Cranbrook Senior School (SSD 8812) – Response to Stage 3 Road Safety Audit

This letter has been prepared as a response to the Stage 3 Road Safety Audit undertaken by DC Traffic Engineering, on the proposed 'Kiss and Drop' facility on the internal driveway.

DRAWING TITLE:
Concept Traffic Management
Sheet 3

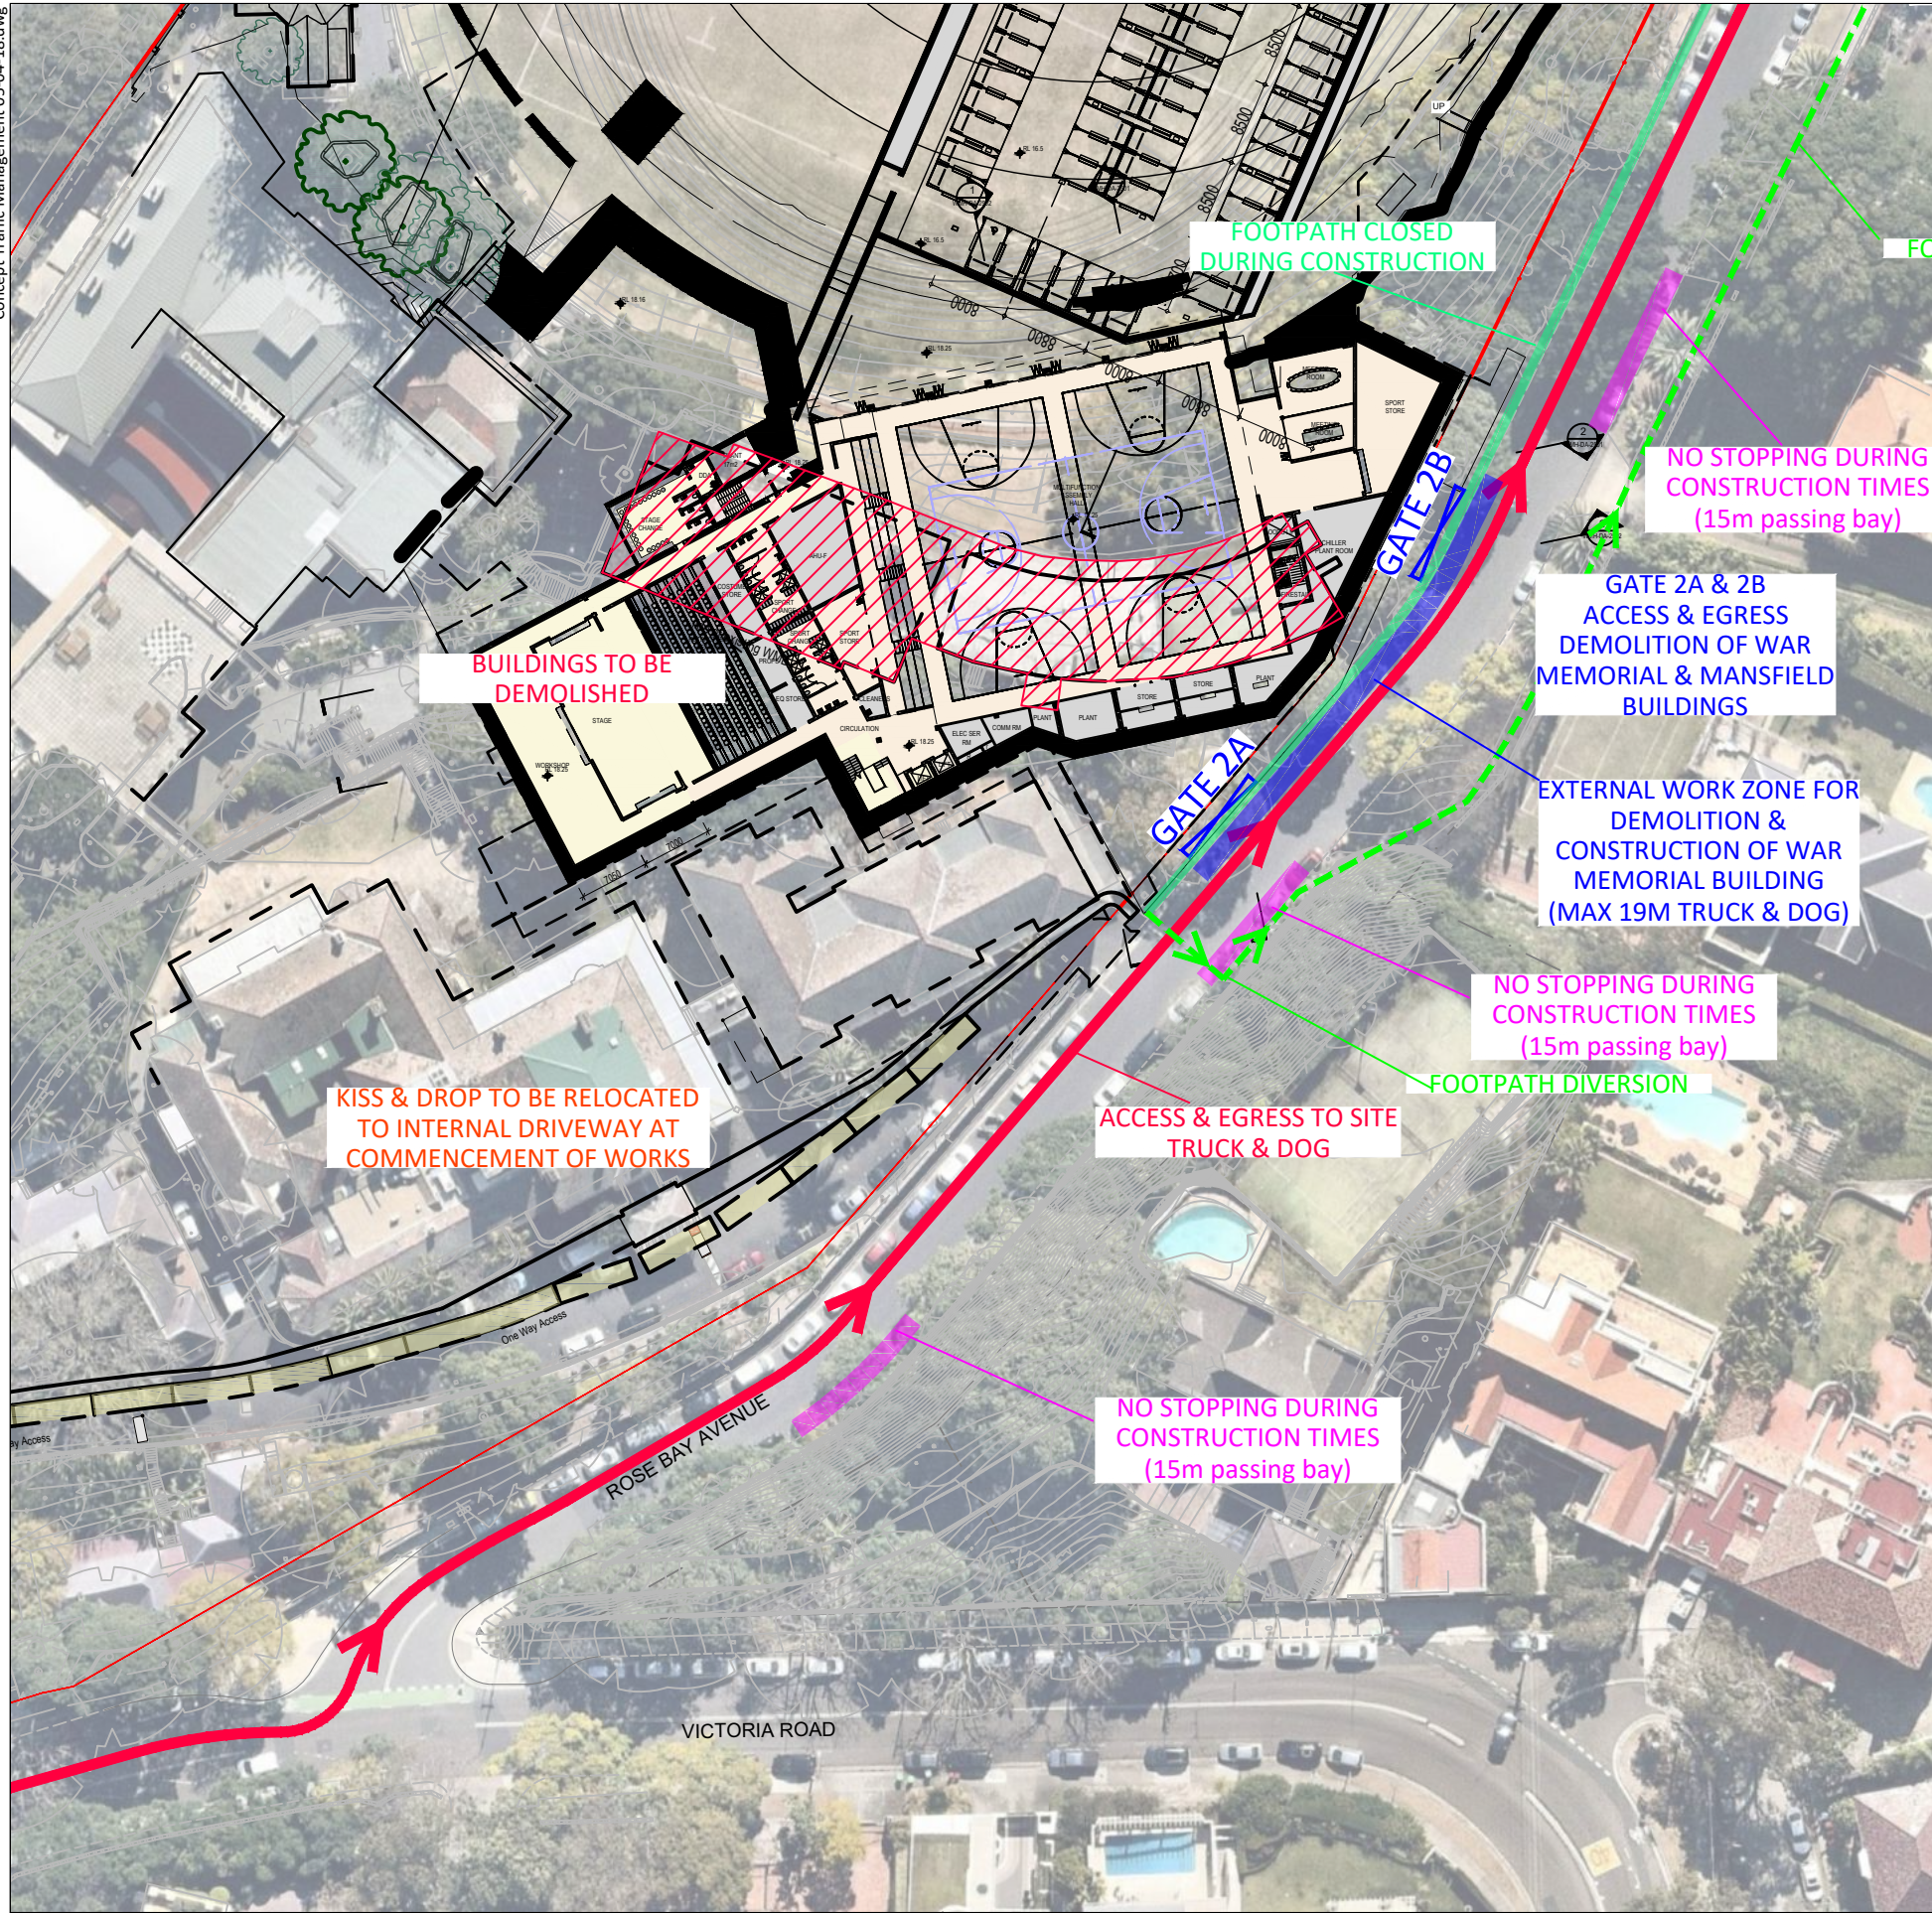
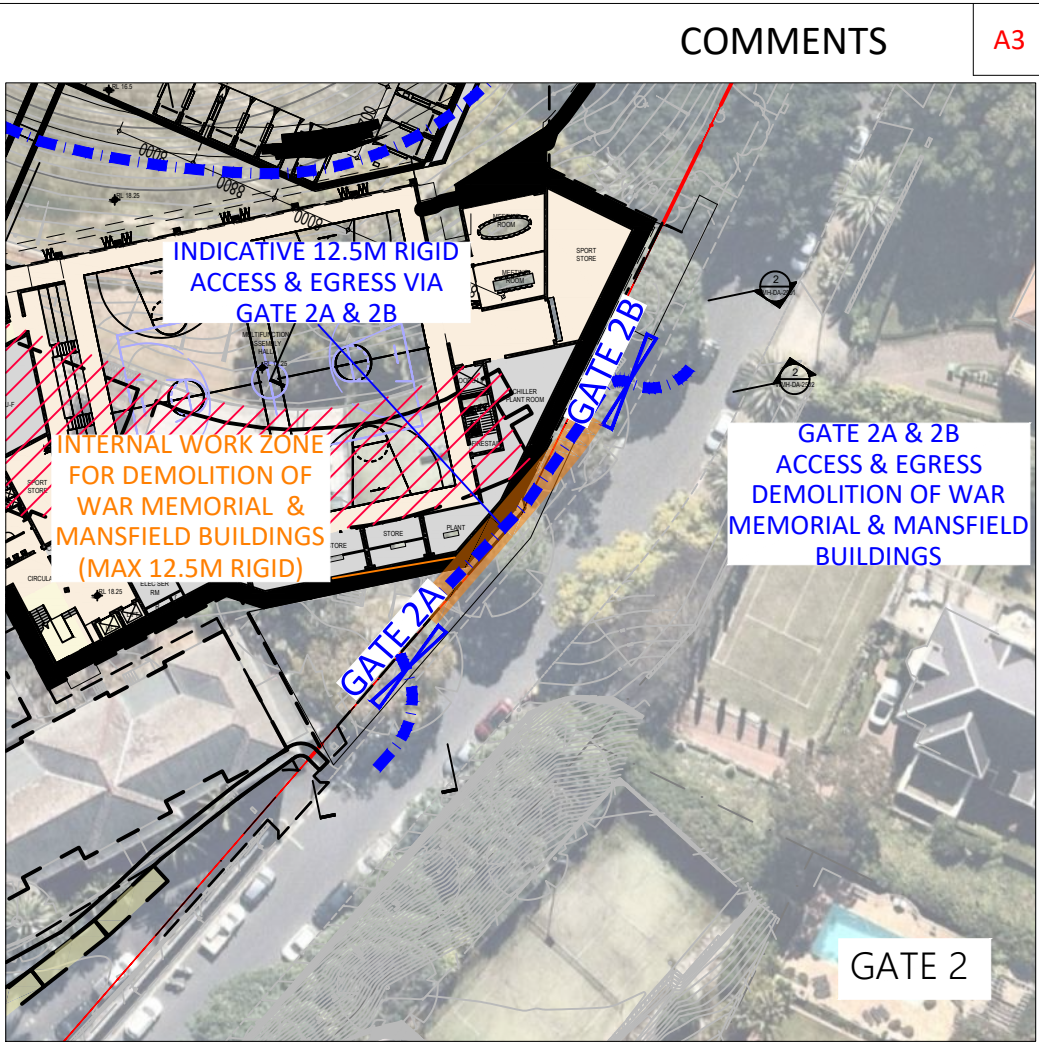
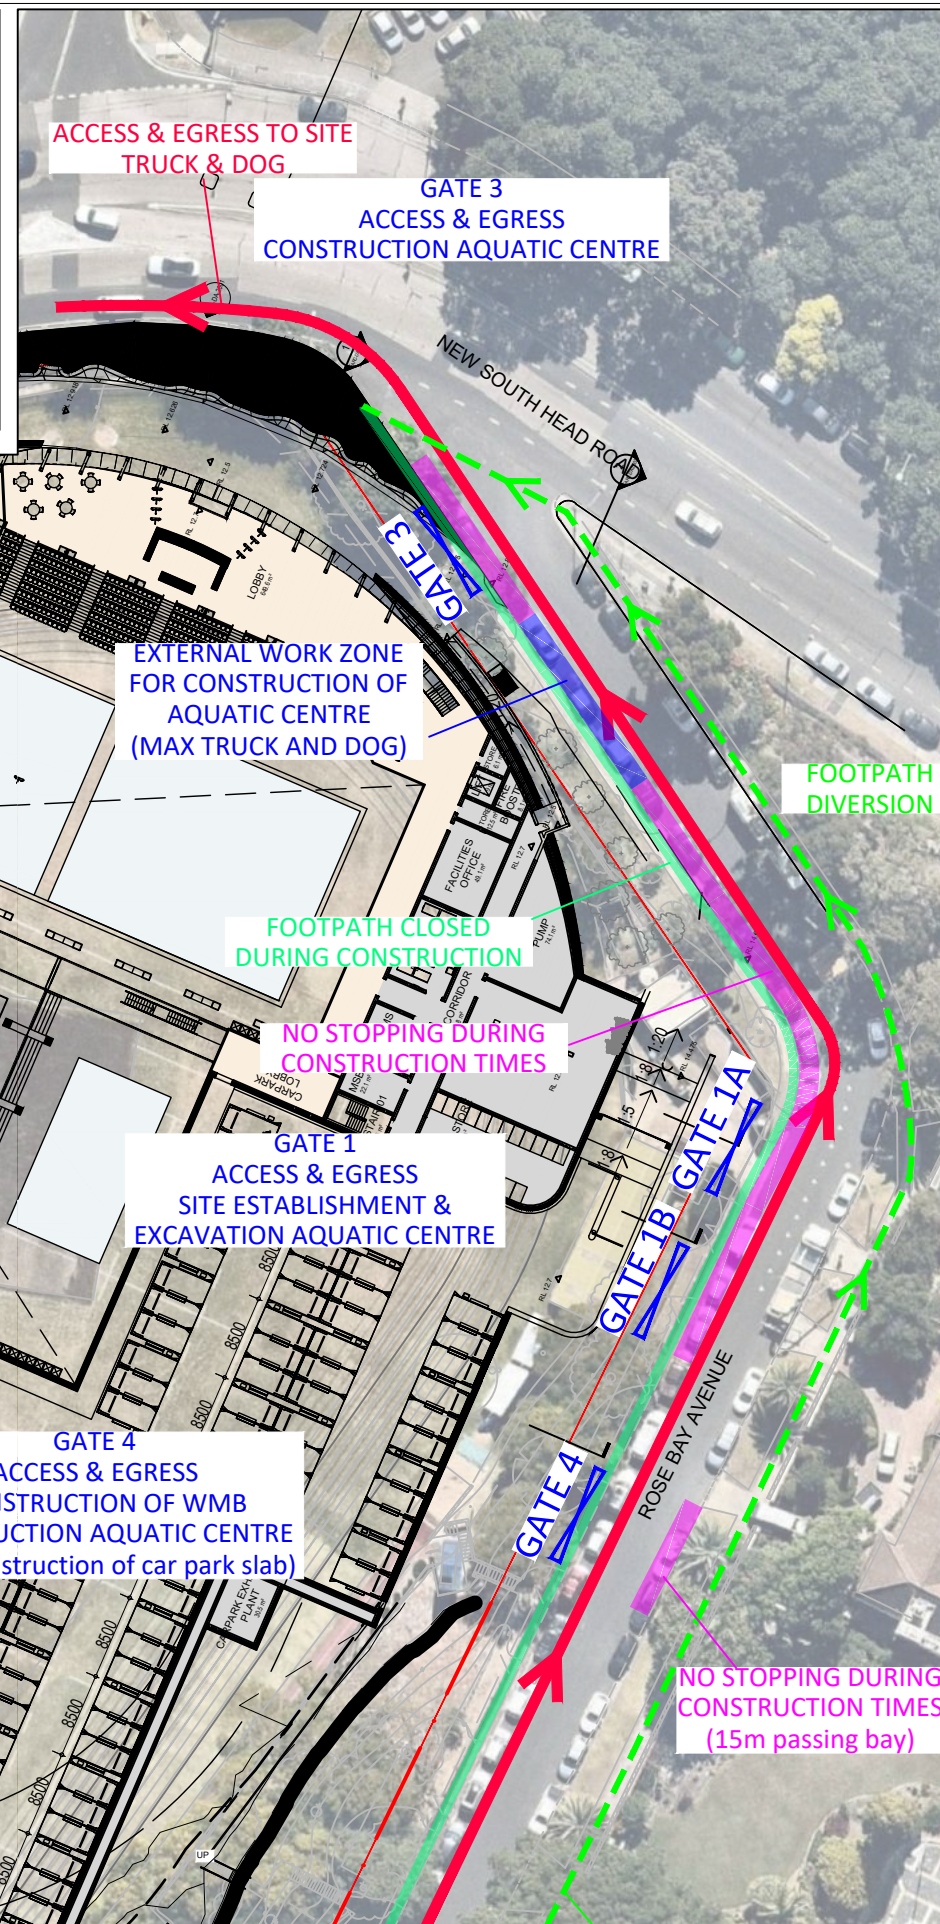
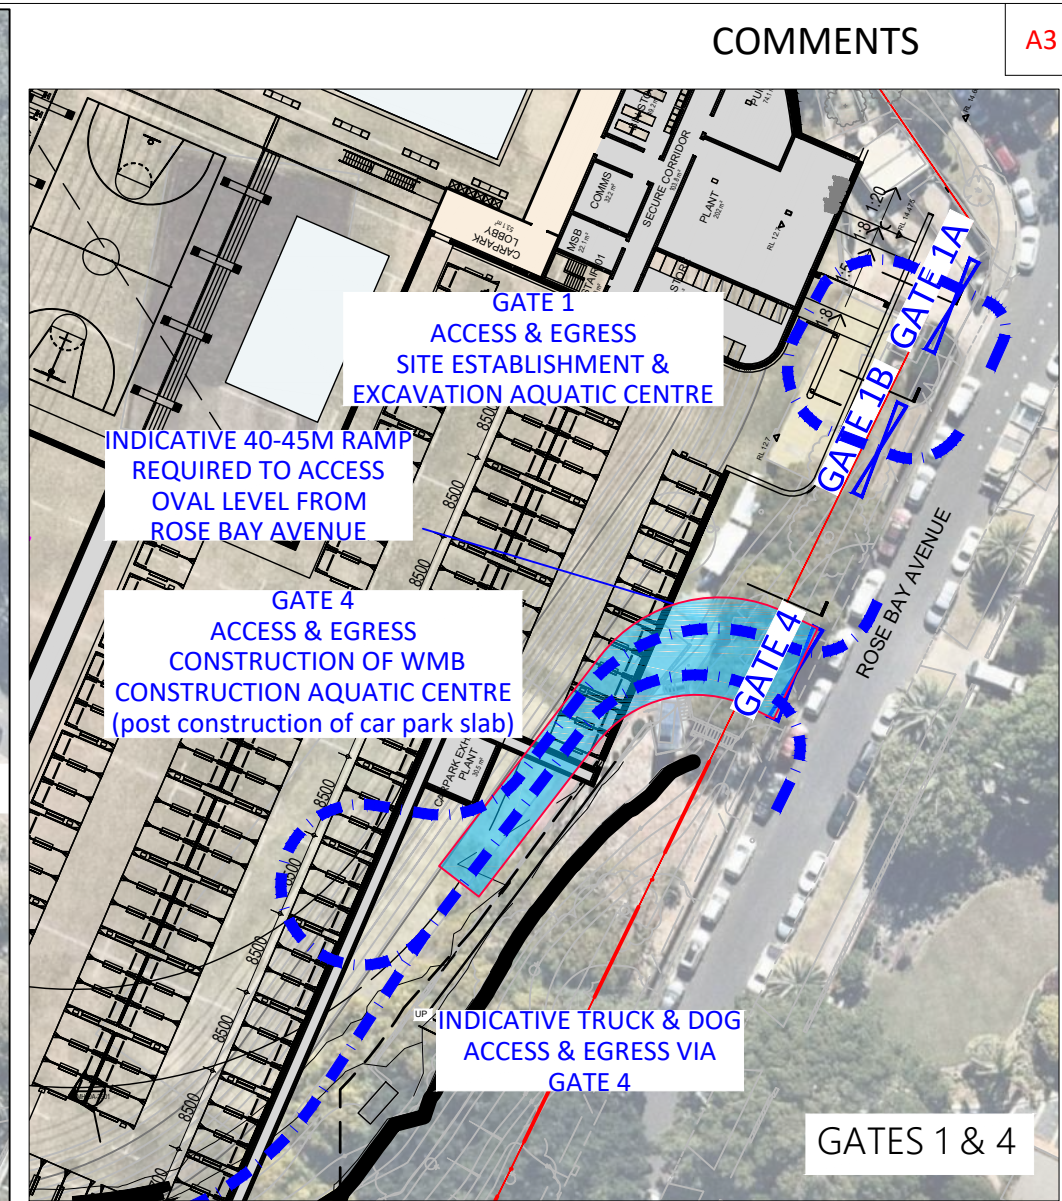
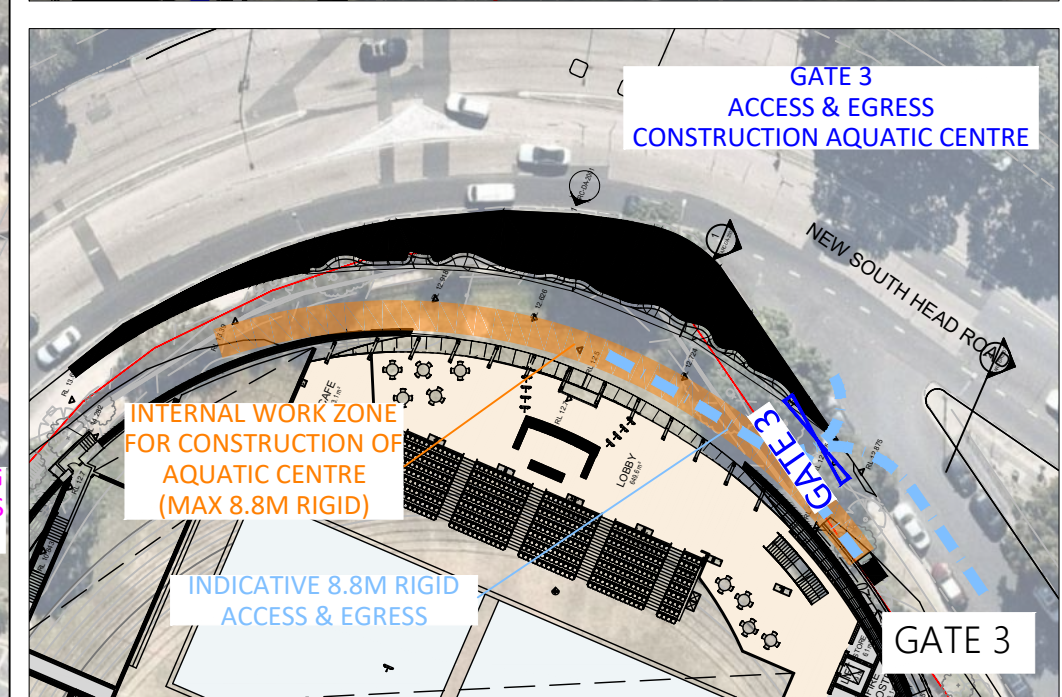
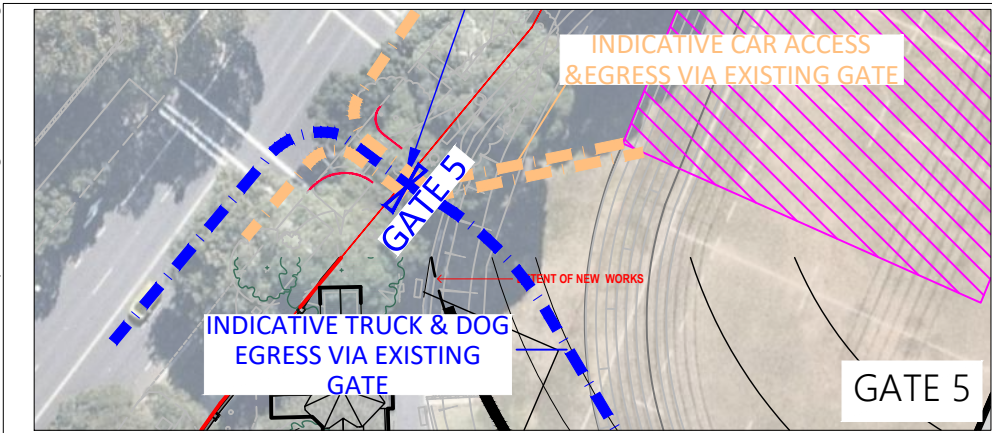
Items 2a, 2b and 2c: General – Lack of passing clearance along the circulation aisle of the port cochere.

Item 3a: Entry gate at Victoria Road.

Item 3b: Entry gate at Victoria Road

Item 5.1: Safety of egress gate.

Item 5.2 and 5.3: Safety of egress gate.

Item 5.4: Safety of egress gate.

Item 6: Egress driveway on Rose Bay Avenue.

- **Response** – Noted: All the parking on the southern side within the kiss and drop area is to be removed and relocated to the underground car park. Therefore, a minimum 3.4m wide circulating aisle will be provided, allowing clear one-way passage adjacent to the kiss and drop spaces. Students will be managed by staff at all times and the speed limit will be reduced to 10 km/h, further reducing the potential of conflicts.

- **Response** – Noted: It is recommended that the right-hand gate of the pedestrian (western) gate will be closed (leaving only the left hand half open), preventing vehicular access. Vehicular access is provided via the eastern gate to provide unimpeded pedestrian access from the bus stop on the north side of Victoria Road.

- **Response** – Noted: Swept path analysis indicates that vehicles can access the eastern gate unimpeded.

- **Response** – Accepted: This could be resolved by providing an ‘open slated’ fence (similar to the gate) for the last two fence panels.

- **Response** – Noted: Vehicles exiting the gate will be in line with the edge of the parking lane on the north side of Rose Bay Avenue and in conjunction with the increased “no stopping” provision across the driveway, we are of the opinion that the visibility will not be restricted.

- **Response** - Noted: A 10 metre section of ‘No Stopping’ is proposed on the eastern side of Rose Bay Avenue (opposite the driveway), to assist with the right turn egress from the driveway.

- **Response** – Agreed: No entry signs to be provided at the Rose Bay Avenue Gate
